**From:** Michael Dierdorff  
**To:** [Robin Proebsting](#)  
**Subject:** File Nos: SUB19-002 (SEP19-005)  
**Date:** Tuesday, May 7, 2019 9:50:36 PM

Re: Public Notice of Application  
File Nos: SUB19-002 (SEP19-005)  
Location of Property: 2825 W Mercer Way  
Parcel No: 217450-2425

PRELIMINARY GRADING PLAN
2825 W MERCER WAY
PRELIMINARY PLAN
 PARCEL #2174502425
 CITY OF MERCER ISLAND WASHINGTON

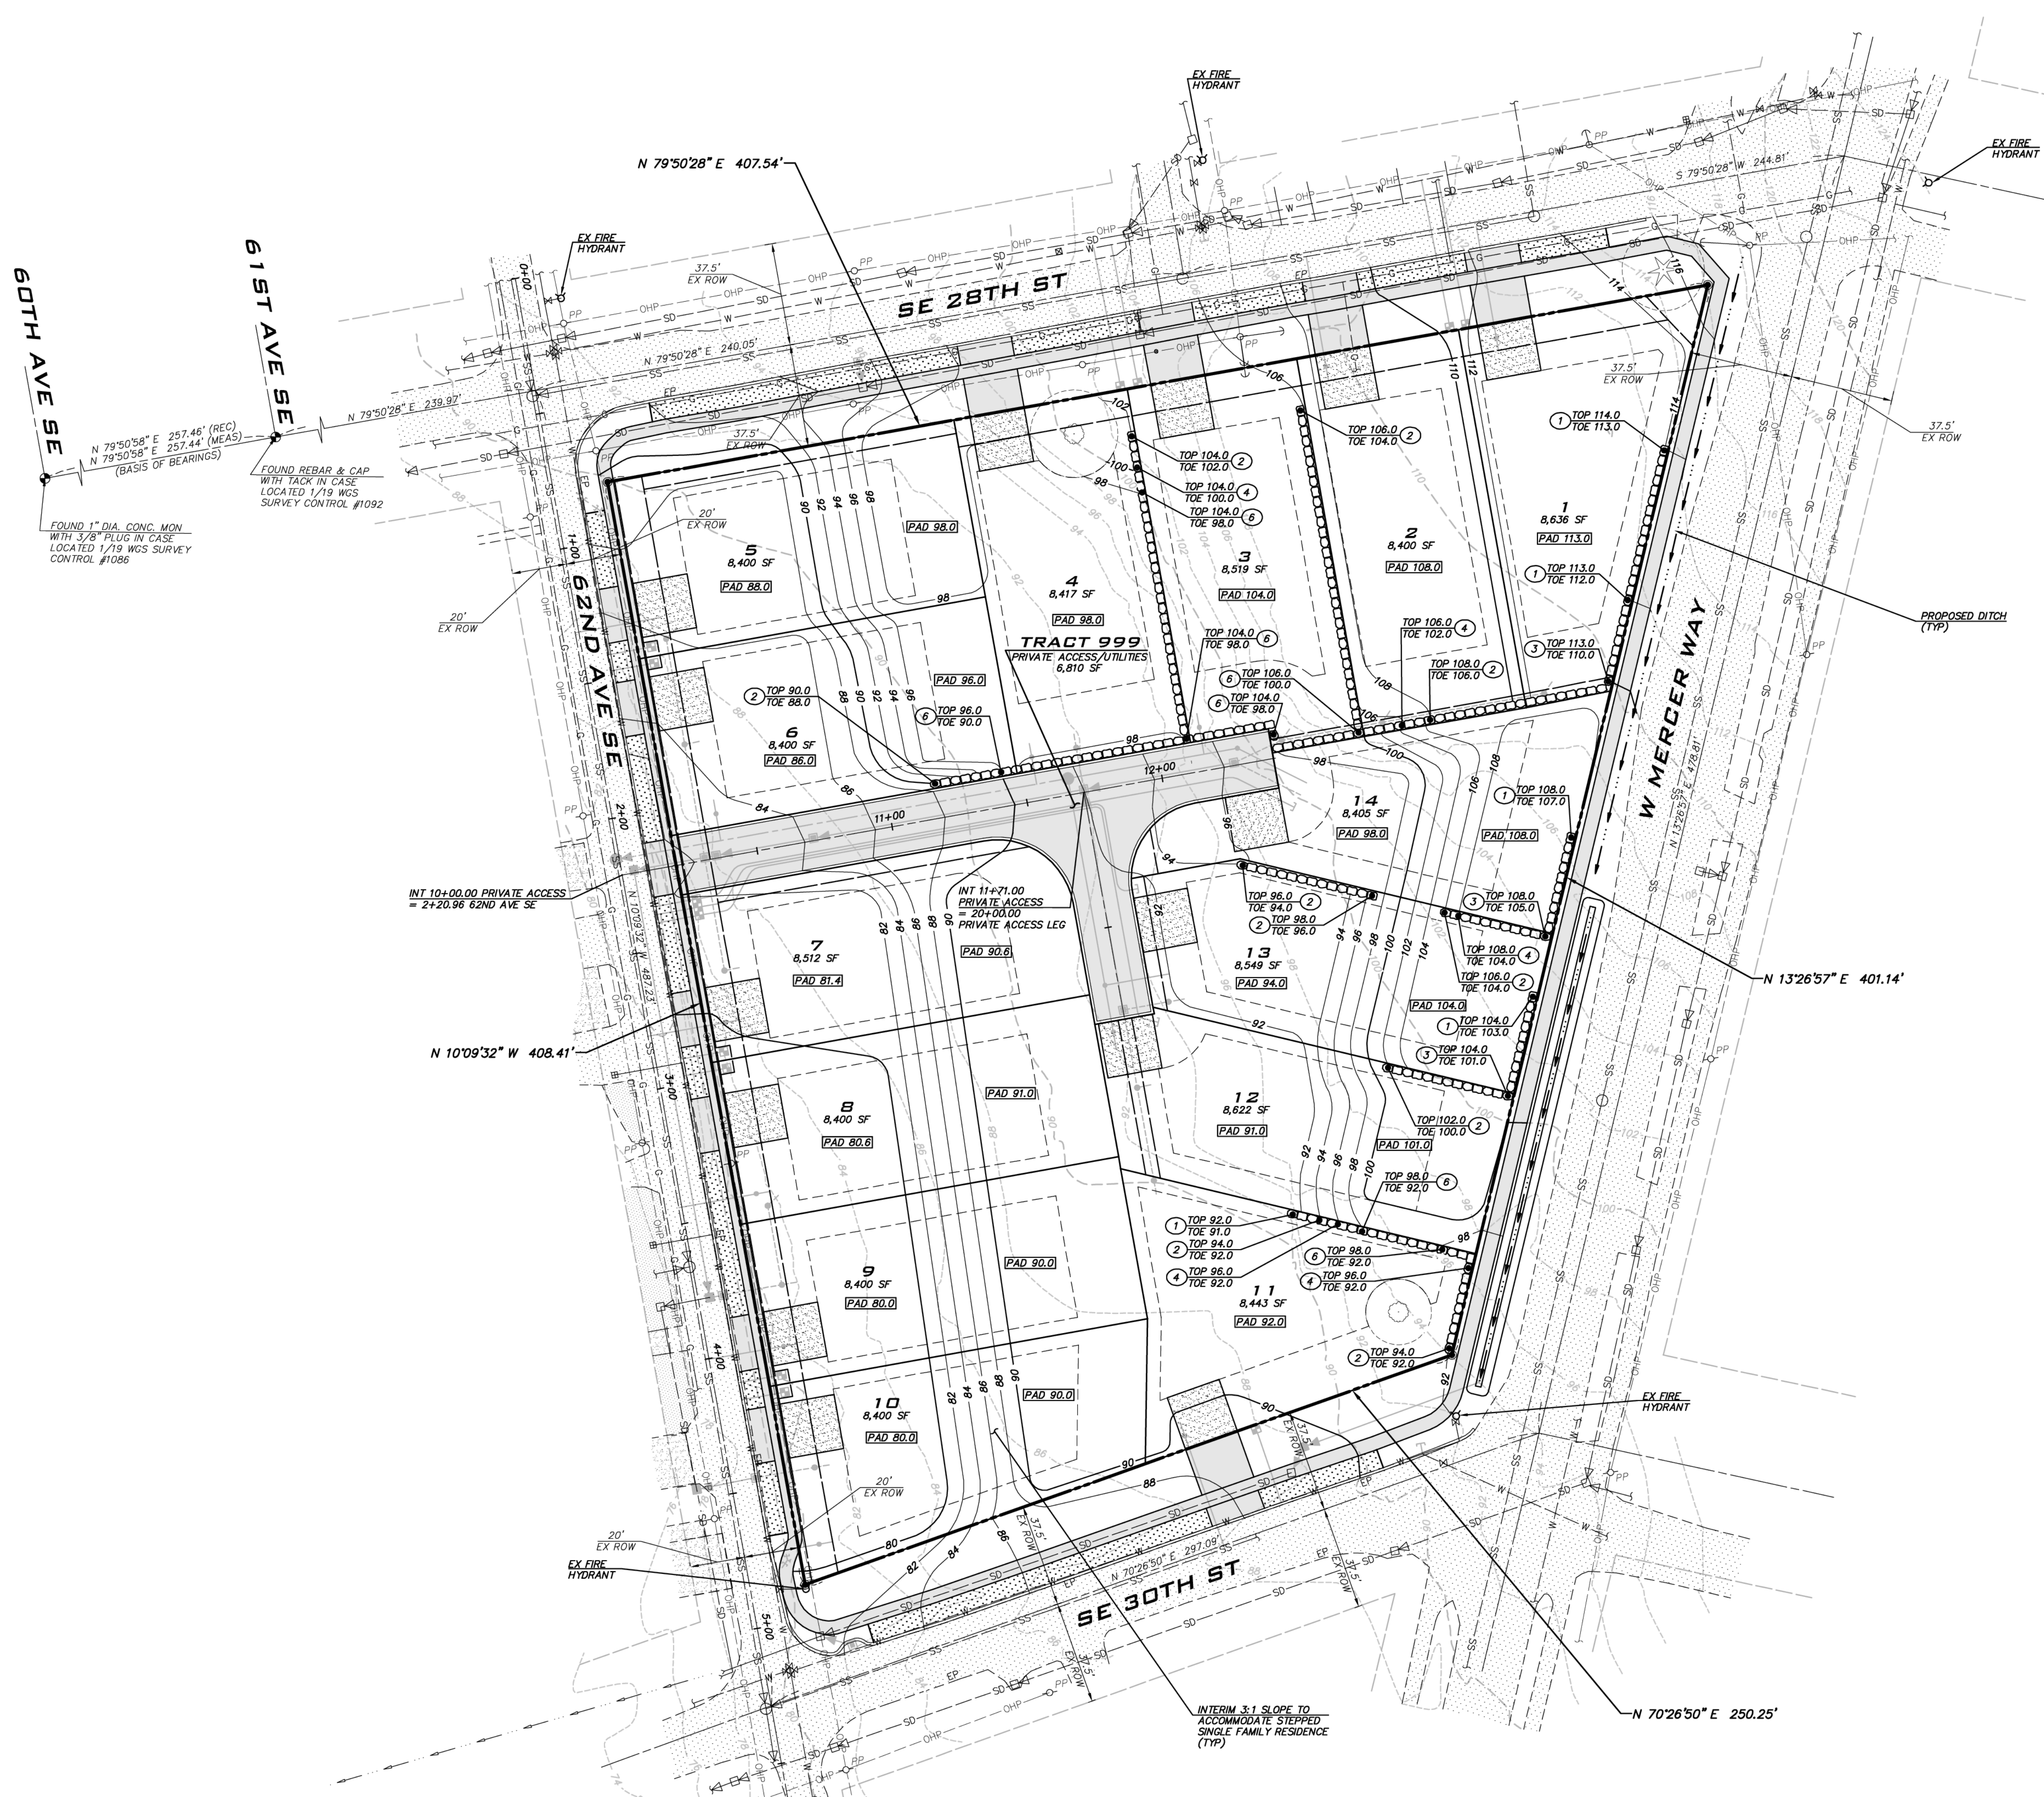
We understand the request for Type IV Plat Application for the future plan of the property to be used for residential housing. We have concerns regarding the grading and that it be kept to the current grade of the existing structure and the height of the existing grade not be increased as they move dirt around. We would also request the land to be developed to fall within current guidelines for square footage of lots which is stated is 8000sf and that no variance be given to allow for a higher density. Additionally, we are concerned with new tree mature heights, night sky view of outside lights and of course the traffic by the additional residents and construction trades.
